RE: Brickworks Proposed Lightweight Concrete Aggregate Facility – 780 Wallgrove Road, Horsley Park: Response to Comments Received on Draft Soil and Water Report

As part of the consultation process with stakeholders required by the Secretary's Environmental Assessment Requirements (SEARs), the draft Soil and Water Report (SWR) prepared by AT&L was submitted to DPI Water for review and comment.

A written response was received from DPI Water on 4 September 2015 outlining several items where further information or clarification was required. The following is an item by item response to the issues raised in the letter. Please also refer to the updated SWR and accompanying civil drawings.

Project	CONCRETE AGGREGATE FACILITY 780 WALLGROVE ROAD HORSLEY PARK
Title	BULK EARTHWORKS CUT/FILL PLAN

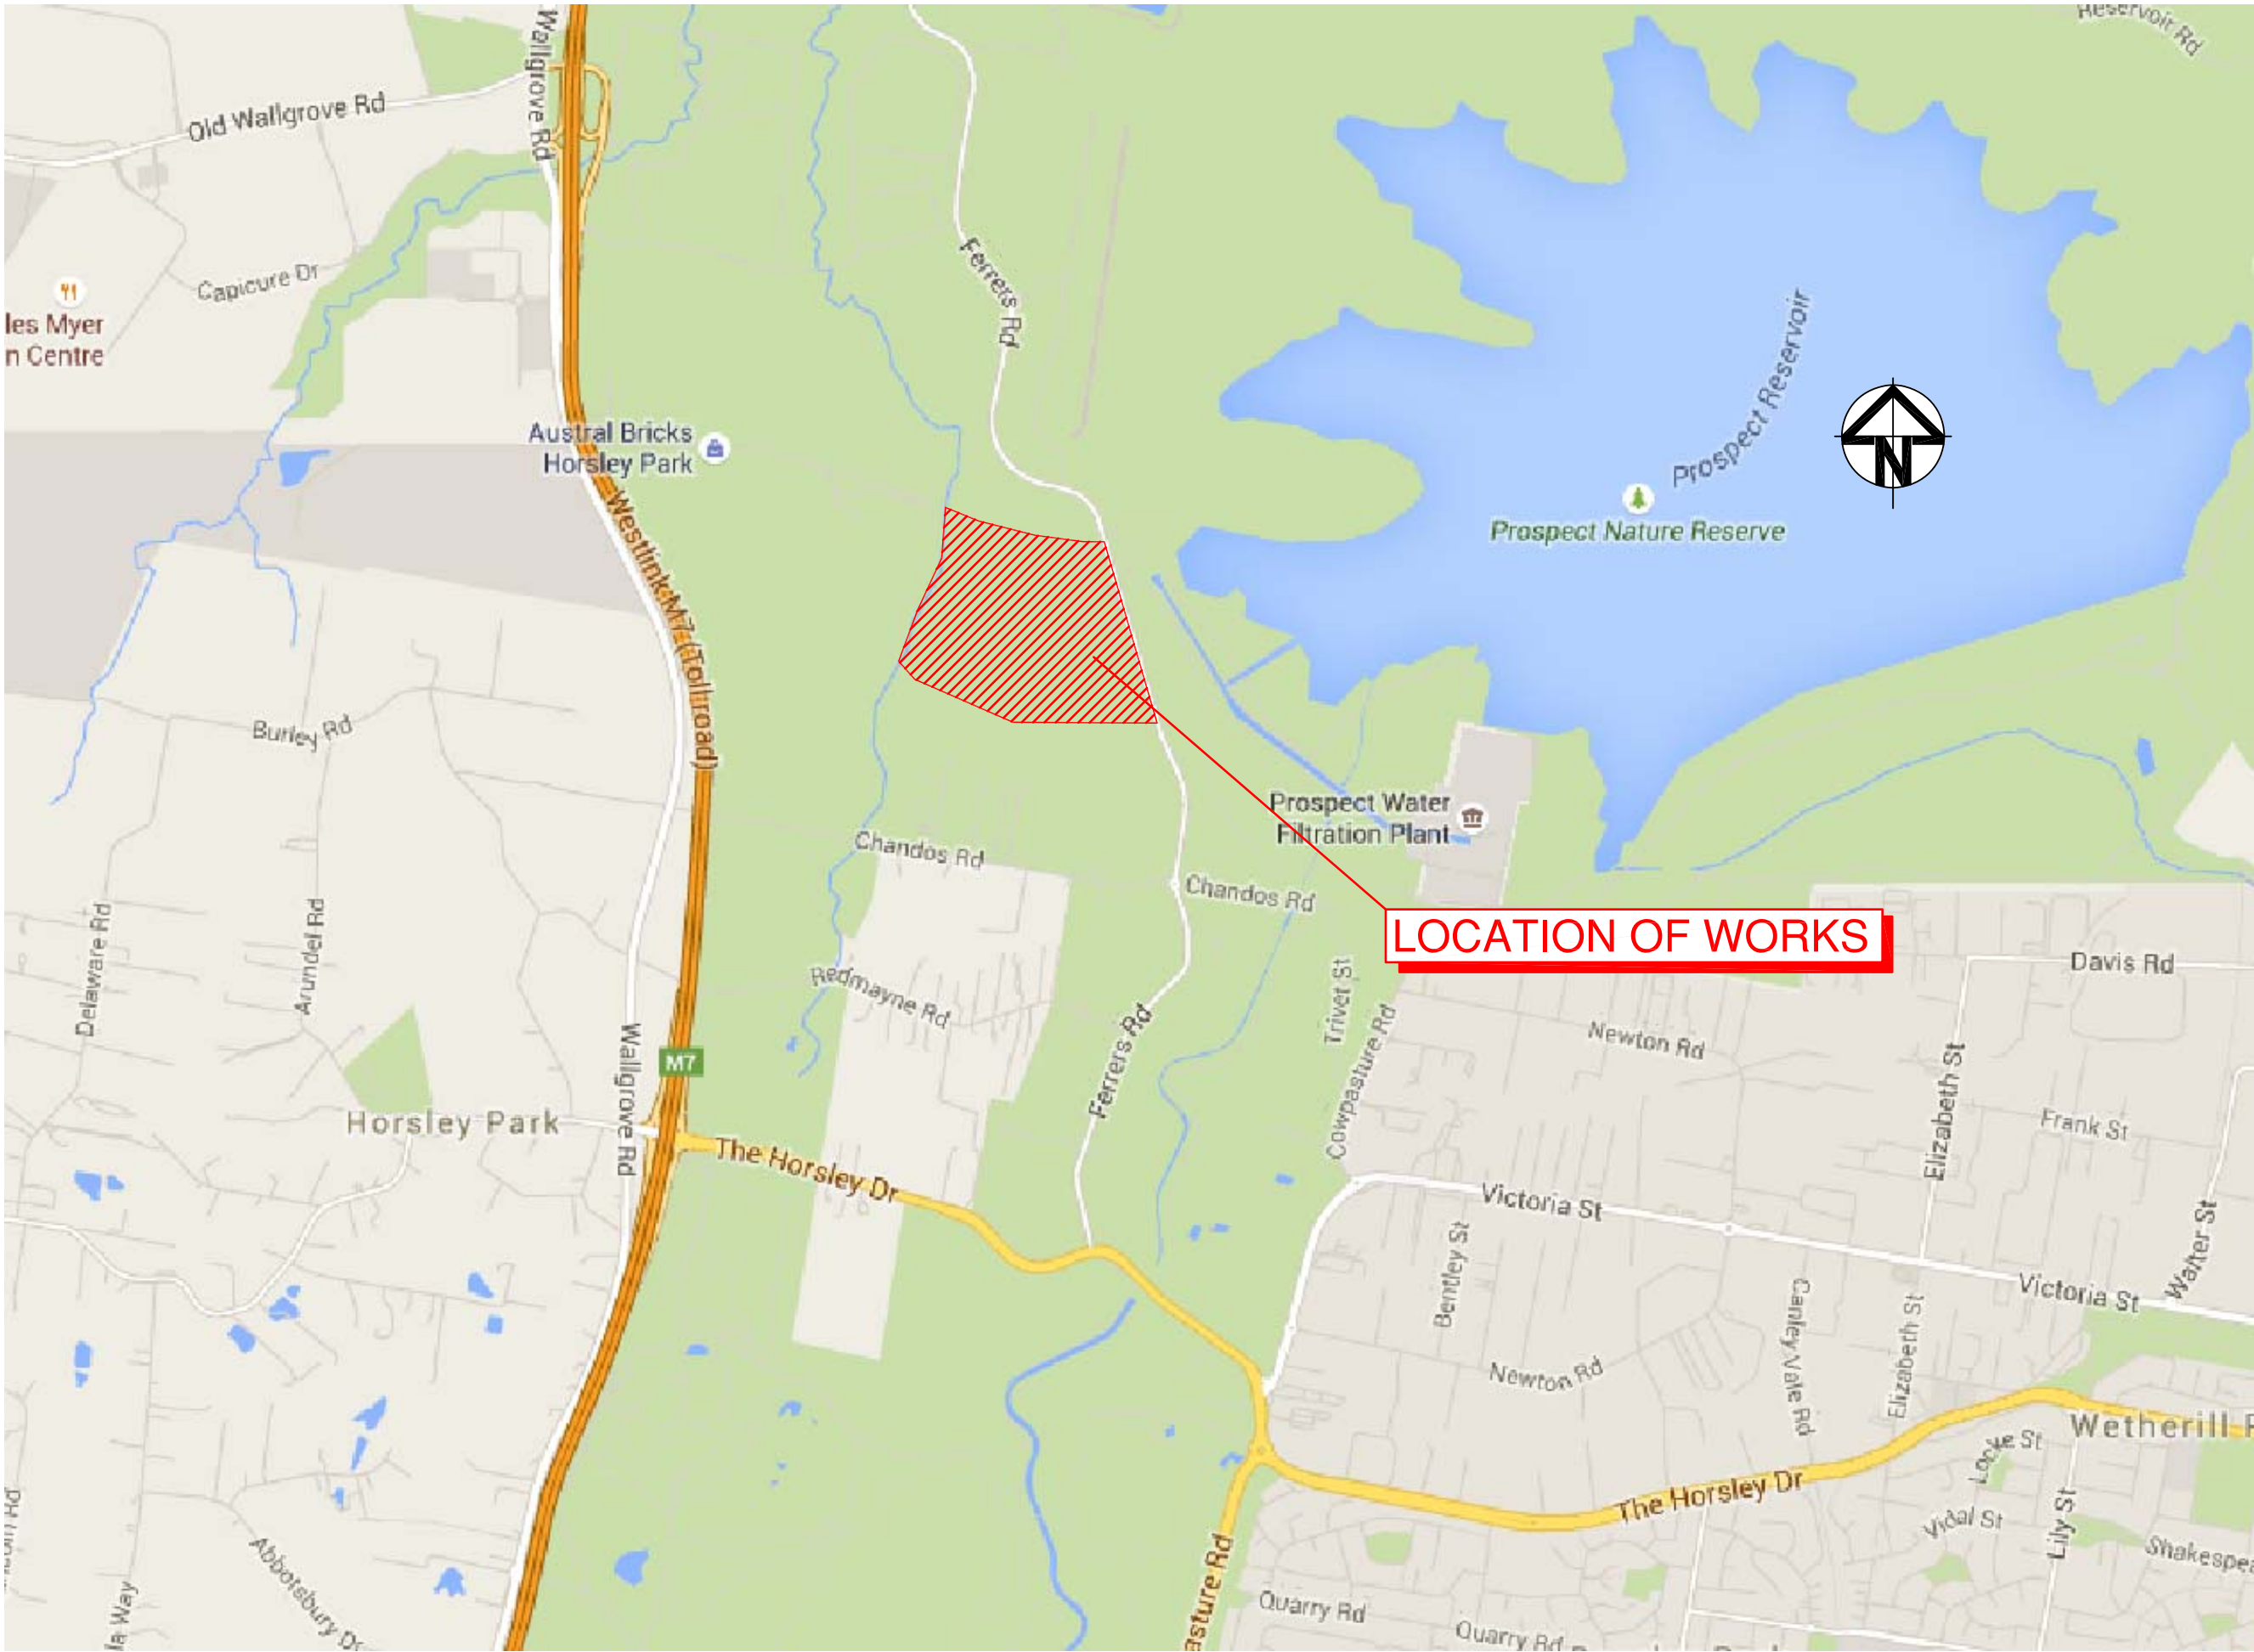
The SEARs require an assessment of potential impacts of the proposal on groundwater and groundwater dependent ecosystems. The SWR indicates that based on historical data groundwater levels on the site are well below (10m+) the proposed bulk earthworks and minimal dewatering (if any) would be required (see pages 4 and 23). Based on the Bulk Earthworks Cut/Fill plan (Drawing No C04) the maximum depth of excavation is 3.5 m below the existing surface level. It is recommended the EIS includes further assessment of the groundwater site conditions within the areas of maximum excavation as shown in red on Drawing No. C04.

- A geotechnical investigation report of the proposed development site has been prepared by Douglas Partners is now available (#84821.00 June 2015).
- The field investigation included monitoring of groundwater levels in boreholes taken around the proposed development site as summarised in Section 4 of the Geotechnical Report.

- The results are summarised in Section 5.2 of the Geotechnical Report. The shallowest depth that groundwater was uncovered was 3.8m at Borehole 4. Groundwater depths at other boreholes ranged up to 12m depth.

- The two shallowest results were at Boreholes 1 and 4 (3.9m and 3.8m depth respectively) although this water is expected to be seepage from a perched water table, rather than an underlying aquifer. In any case only filling is proposed in these locations, no excavation. Finished surface levels will be approx. 5m above the groundwater surface here.

- At the locations where the deepest excavations are taking place (at Boreholes 7, 9 and 10) the depth of groundwater is significantly deeper. The finished ground levels will still be at least one metre above groundwater.

- Section 9.6 of the SWR has been updated based on the information contained within the Douglas Partners report.
